Rampion 2 Wind Farm

Tree Preservation Order and Hedgerow Plan

Revision B

Application Reference: 2.6

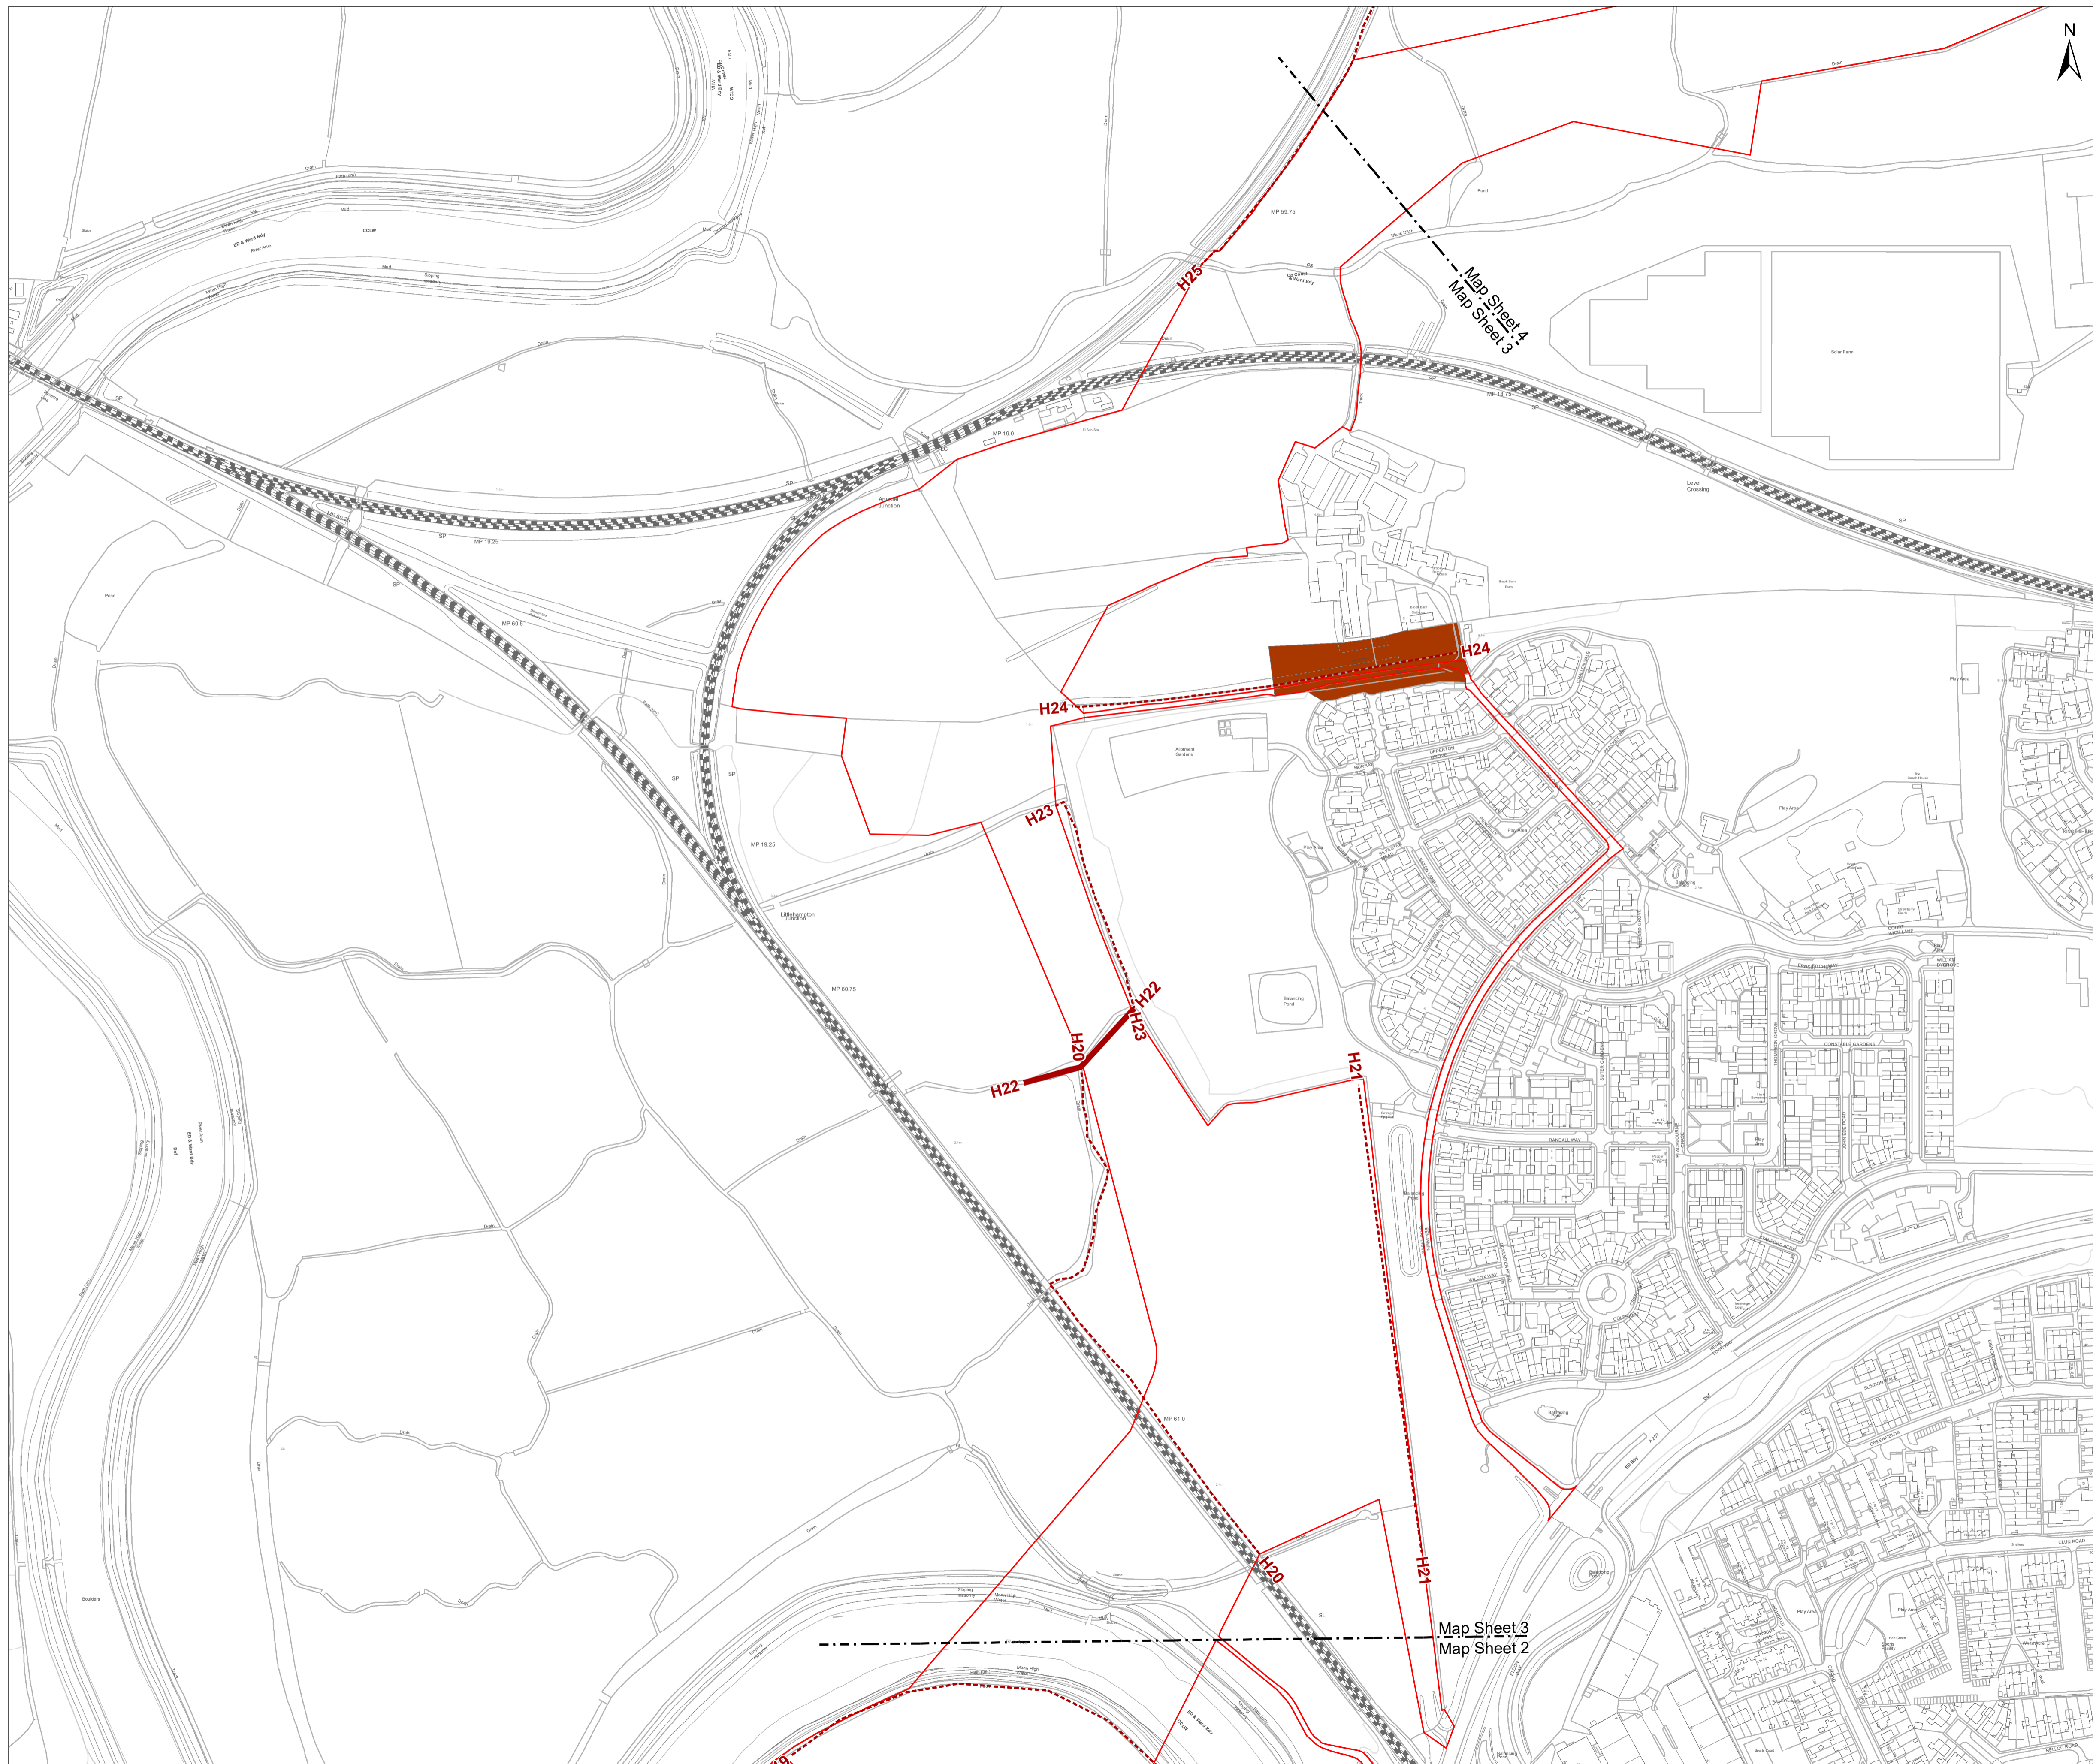
Revision	Date	Status/reason for issue	Author	Checked by	Approved by
A	04/08/2023	Final for DCO Application	WSP	RED	RED
B	16/01/2024	Corrections to H13 (Sheet 02), H27 (Sheet 04) and H456 (Sheet 34), amended from hedgerows unaffected to hedgerows which may be removed. H377 (Sheet 29) amended to an Important Hedgerow.	WSP	RED	RED
